From: Sue Howell <Sue.Howell@arun.gov.uk>
Sent: 22 February 2022 12:07
To: Planning.Responses <Planning.Responses@arun.gov.uk>
Cc: Simon Davis <Simon.Davis@arun.gov.uk>
Subject: Planning Consultation on: AL/141/21/RES

Application ref: AL/141/21/RES

Description: Approval of reserved matters following outline planning permission AL/21/20/OUT for the approval of the appearance, layout, scale and landscaping for 5 No 4-bed dwellings, 14 No 3-bed dwellings & 19 No 2-bed dwellings. This site is in CIL Zone 3 and is CIL Liable as new dwellings.

Location: Land North of Lee's Yard Lidsey Road Woodgate PO20 3SU

Drawing Name Landscape Strategy

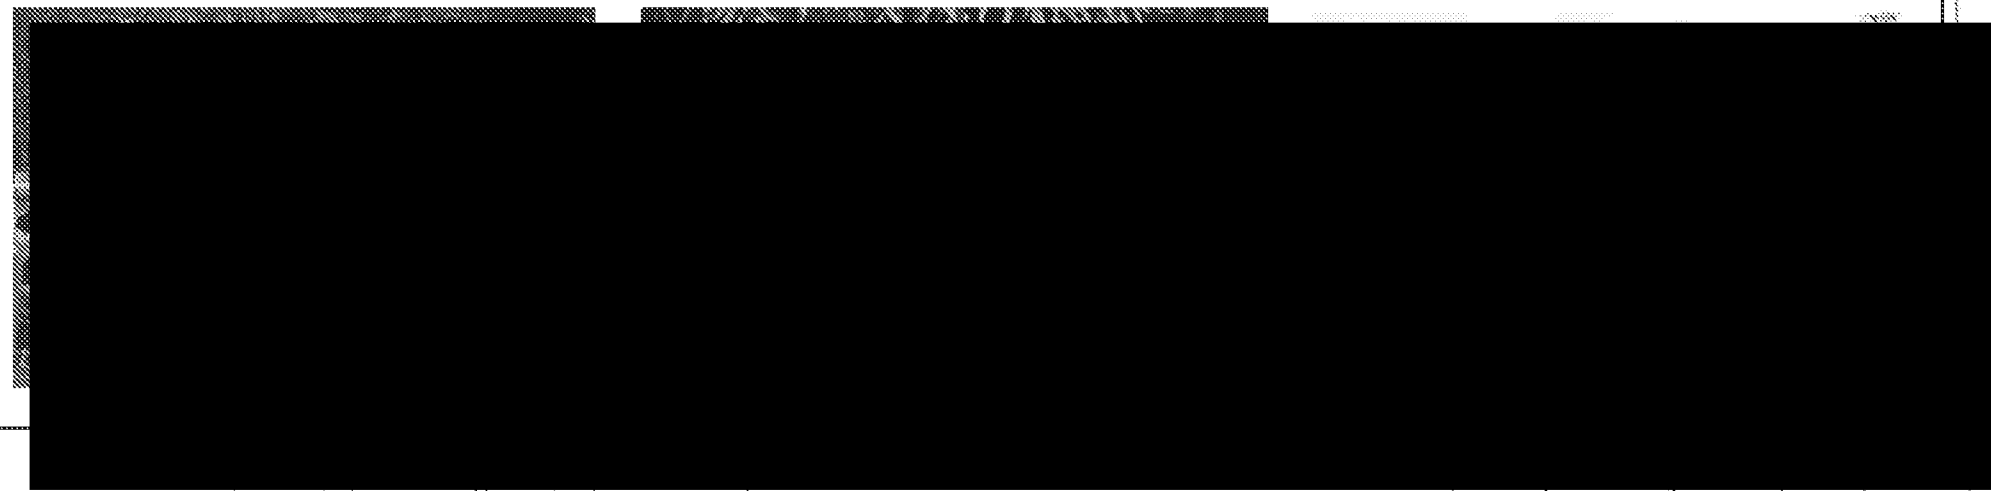
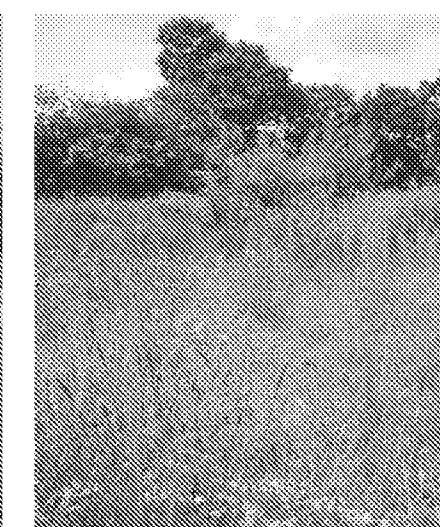
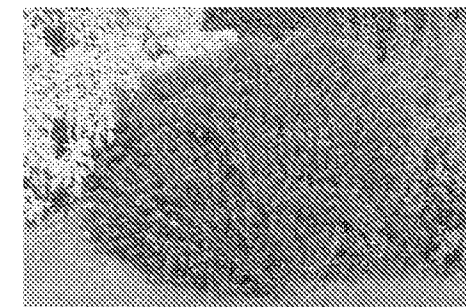
Landscape information has been provided within the Planning Layout dwg 21452/5000 B which makes reference to see Landscape Architects details – (these do not appear to have been submitted), further information has been supplied within the Design Compliance Statement and the Landscape Strategy CSA/5748/100 and Ecology Enhancement Plan Dec 21 (page 10) All the above **have provided illustrative information only** ie detailing Semi Mature trees to soften, but none of the information provided appears to show actual quantities, species in location or size at time of planting. This information will need to be supplied in plan form with detailed tree and shrub specification.

LEAP location and area detail is indicated within Planning Layout dwg 21452/5000 B, but again **no detail has been provided regarding play equipment choice and specification**, fencing and surfacing details. The play area needs to provide an inclusive offer of play and be accessible in line with the SPD 13 Arun District Design Guide (SPD) January 2021.

The landscape detail needs to show a landscape scheme which is fitting for location providing a good mix of native and ornamental trees and shrubs with suitable planting densities and size at time of planting. The layout of the residential areas and dwellings appear to have direct access to the POS areas. The green corridor surrounding and to the south of the development site has the potential to aid and enhance wildlife and biodiversity habitat.

The SuDS features within the POS areas will need to be quantified and confirmation provided that excluding these features the quantum of usable POS still conforms to our Open Space, Playing Pitches, Indoor and Built Sports Facilities SPD, Jan 2020.
